Subject: Re Planning Application EP/67/20/PL 47 The Ridings, East Preston.

47 The Ridings, East Preston

We wish to make the following objections/negative comments re the above Planning Application.

DRAWING TITLE
PROPOSED SITE LAYOUT

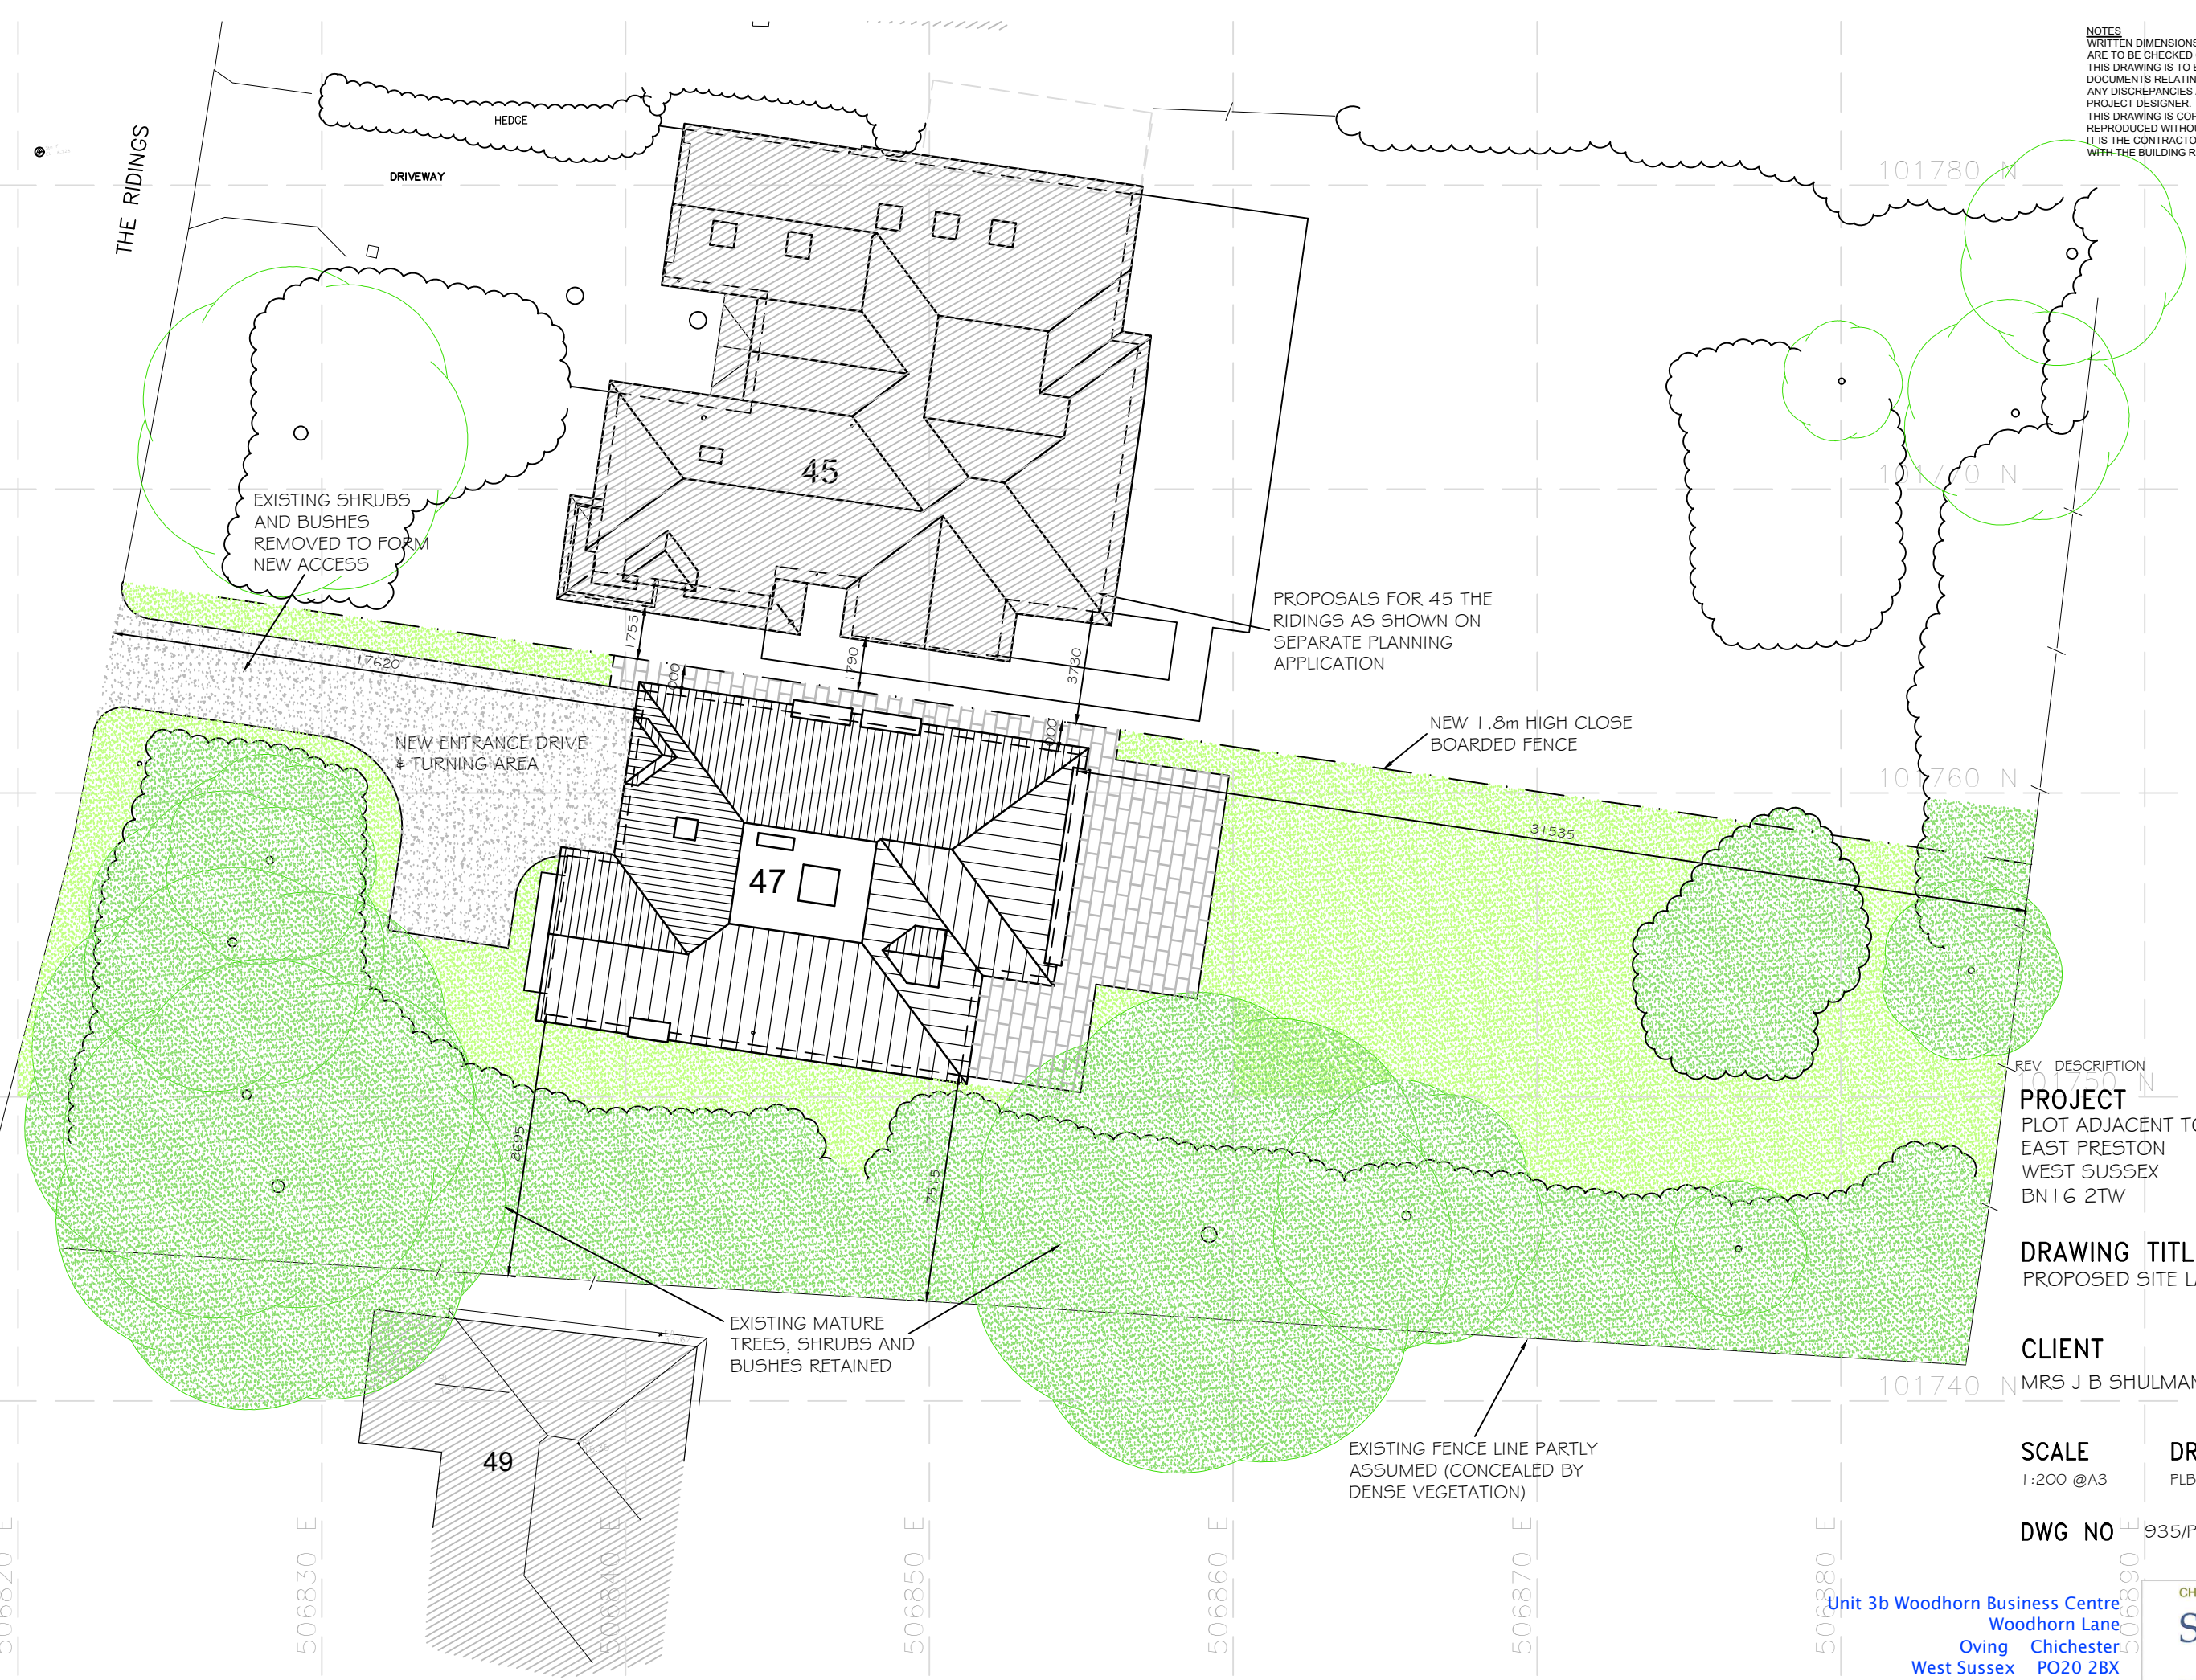
There are 6 bedrooms shown on the plans, but only a single car garage. The driveway is quite short, not very wide with a small turning(?) area. Where will the vehicles that one expects to belong to the inhabitants of a 6 bedroomed house park? Also the vehicles belonging to any visitors to the property? The Willowhayne Estate policy is that parking is not permitted on estate roads.
